Date: 02-Jul-2024  
Our Ref: 2023/92092

**Application for Approval of Details Reserved by Condition  
Town and Country Planning Act 1990  
Planning (Listed Buildings and Conservation Areas) Act 1990**

**Discharge of condition 5 (new retaining walls) of previous reserved matters  
approval 2022/91047 for a development of 91 dwellings, pursuant to outline  
permission 2019/90527 (for erection of up to 127 dwellings, with details of access)  
Blue Hills Farm, Whitehall Road West, Birkenshaw, BD11 2DU  
Application Number: 2023/92092**

TITLE
 Countryside Partnerships
 Blue Hills Farm Estates
 Redi-Rock Wall Design
 3.36m

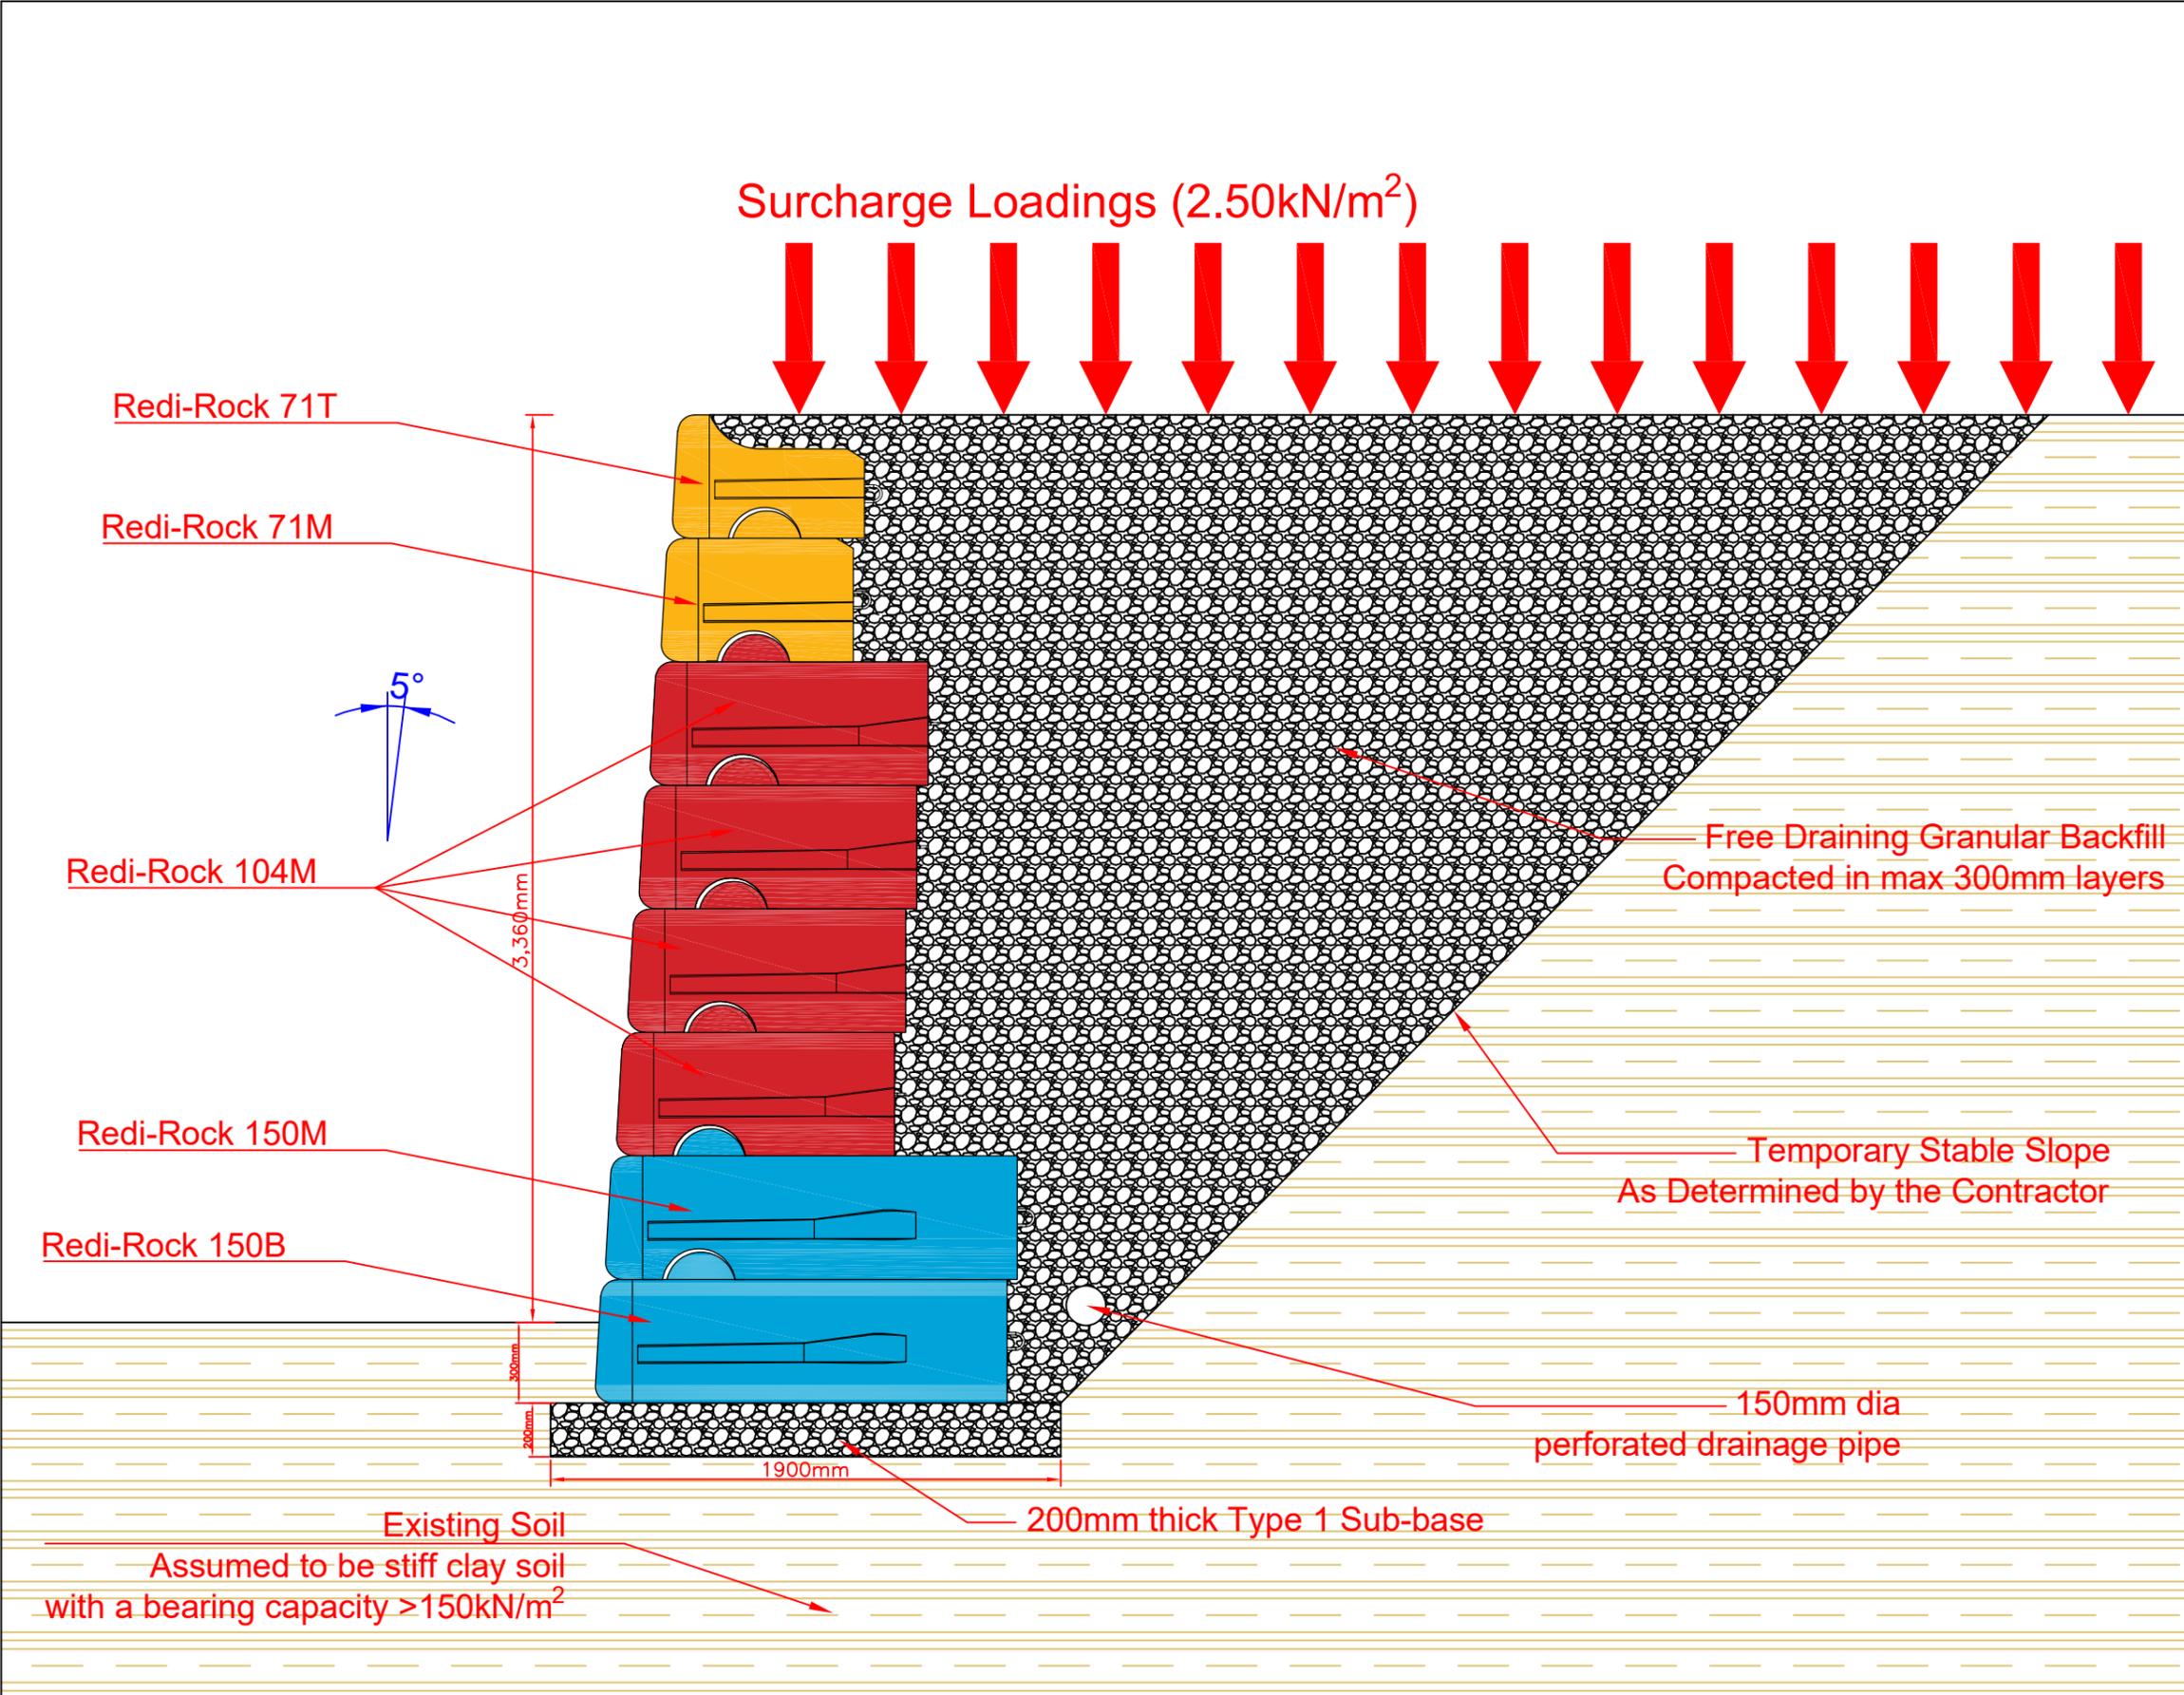
However, officers have significant concerns regarding the height and stark materials used for the retaining boundary wall, due to its prominence along the A58 and the fact that the area is characterised by lower boundary treatments which feature more appropriate materials.

As such, the retaining wall cannot be supported and therefore condition 5 cannot be discharged.
